**RE: Response to City Staff Review Comments
Final Site Plan Application
Hotel Redevelopment
1210 Brighton Avenue
Portland, Maine**

We have reviewed the City staff comments provided for the Preliminary Site Plan Application. Please find our responses to the comments below in *italics*.

2 HYDRANT DETAIL
C4.1 NOT TO SCALE

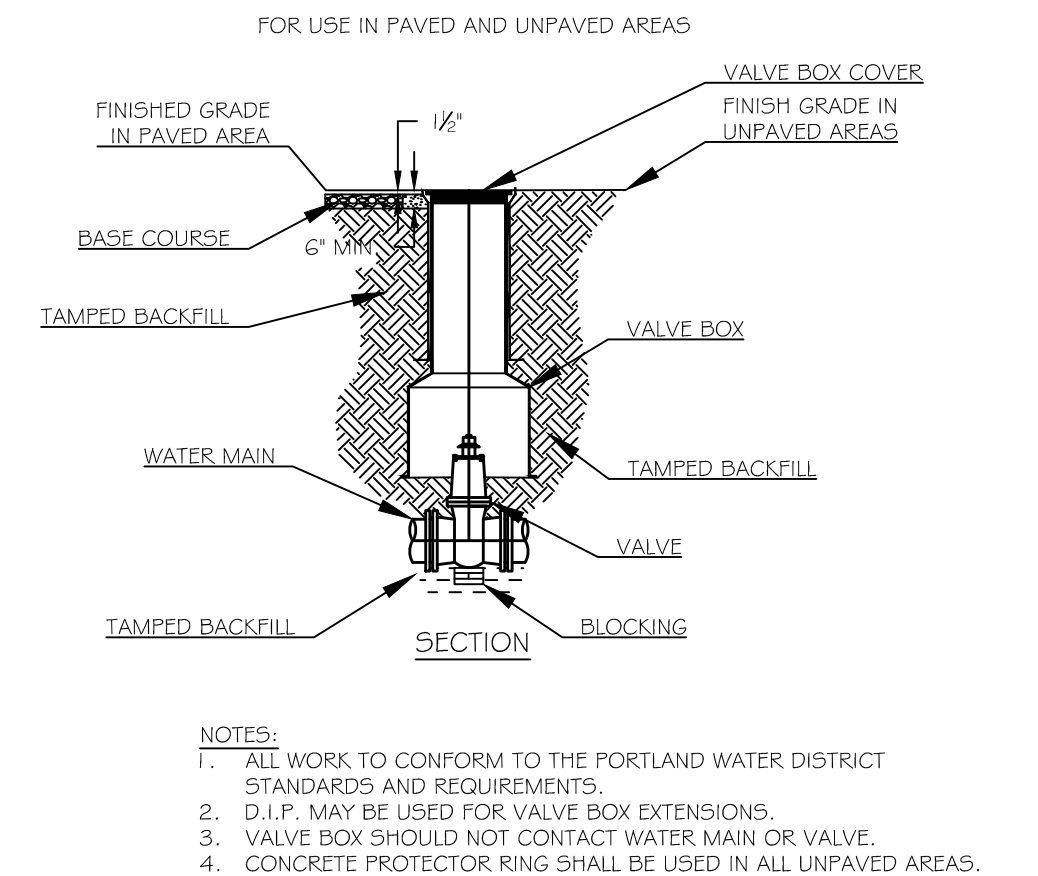
1. Please add the following Conditions
 - a. Private hydrants shall be maintained clear of snow during the winter months.
 - b. Private hydrants shall be painted as follows:
 - i. Bonnet: Gray
 - ii. Caps: Silver
 - iii. Barrel: Red

Fire hydrant notes have been added to sheet C2.0 indicating the information above.

1 RIP-RAP APRON (PIPE OUTLET)
C4.5 NOT TO SCALE

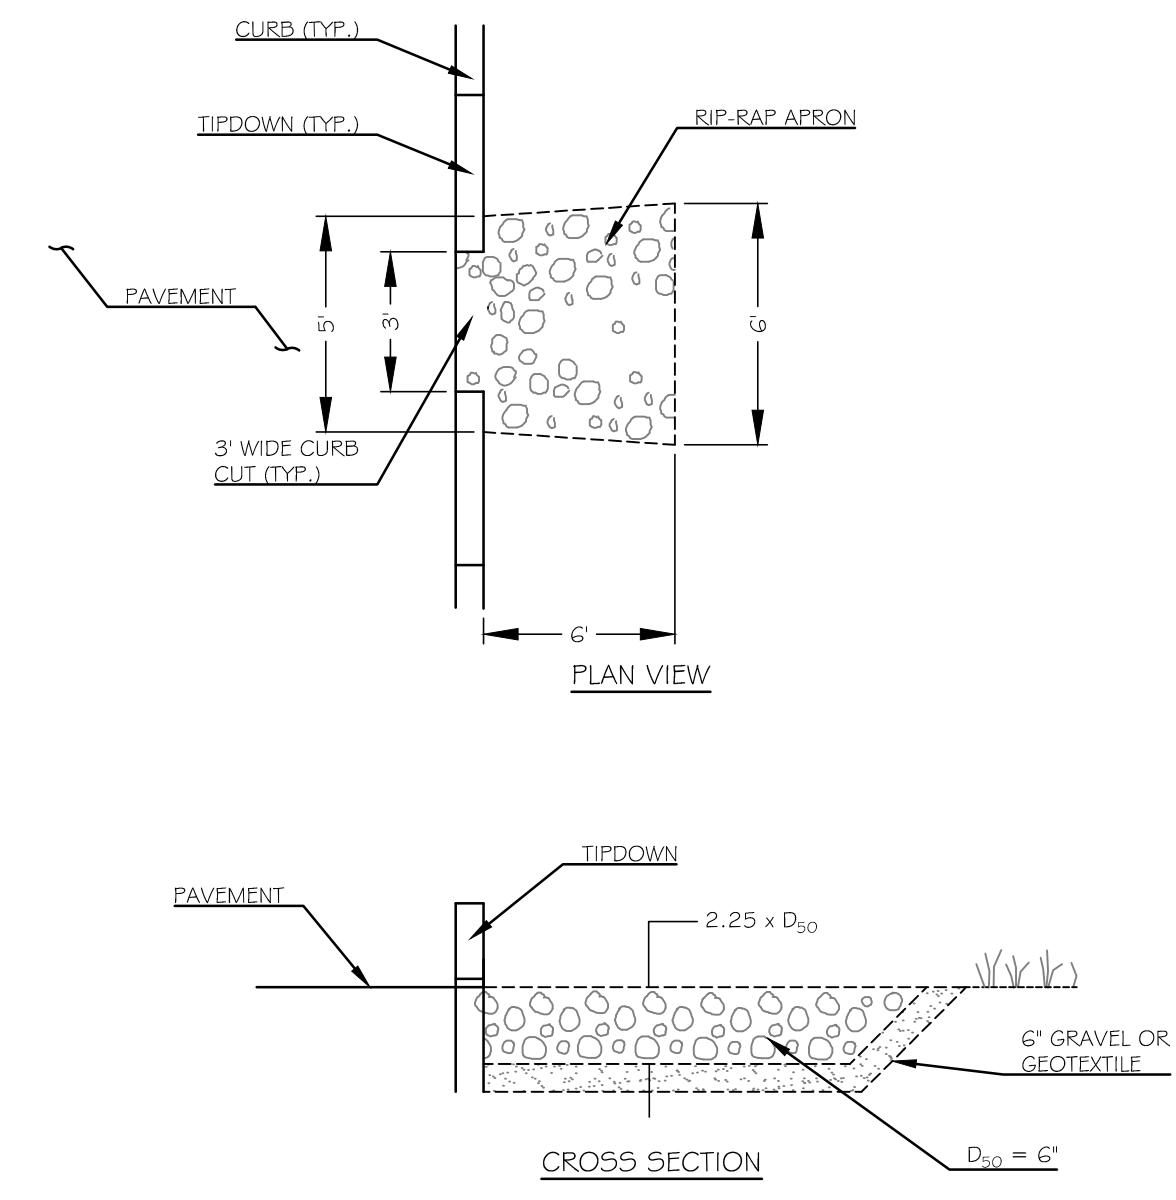
2. A stormwater outfall proposed on the southern portion of the site (AP#2 on sheet D2.0) discharges to an existing swale within a CMP easement. The Applicant proposes a riprap apron at the pipe outlet, and Walsh Engineering Associates has stated that they will review the condition of the existing pipe outlet and swale when the snow has melted to determine if additional stabilization will be required. We recommend that Site Plan approval include a condition requiring that the Applicant's engineer inspect the stormwater outfall AP#2 on Sheet D2.0 and provide a written description and photographs of this outlet, along with any additional proposed stabilization measures for review and approval by the City.

WEA will assess and document the condition of the outfall location once the snow has melted and will provide design details to the city for any required stabilization measures.

6 RIPRAP SWALE DETAIL
C4.5 NOT TO SCALE

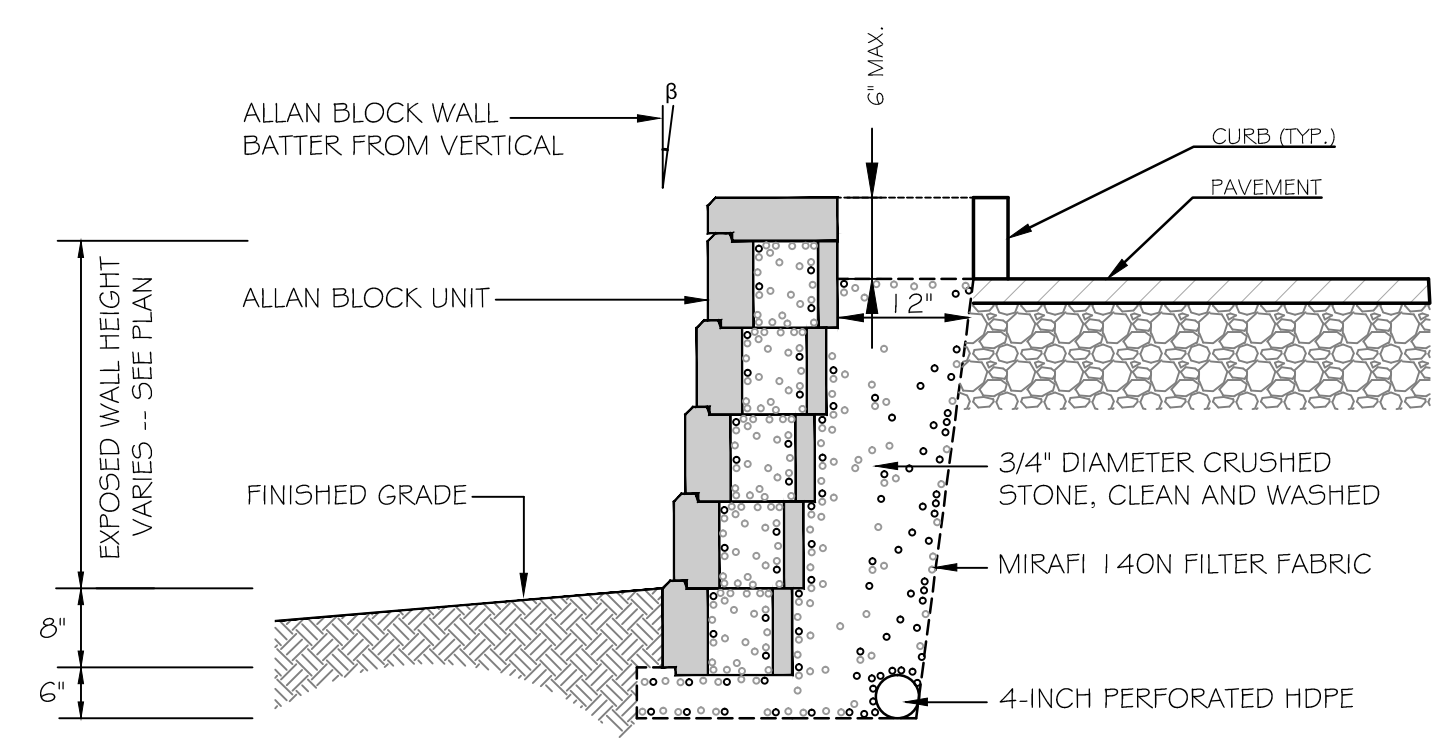
2. The applicant shall supply and easement for the riprap swale areas on City property discharging stormwater across the existing Portland Pipeline easement.

The plan has been revised to indicate that a construction and drainage easement shall be obtained from the City of Portland for the area associated with the riprap swales.
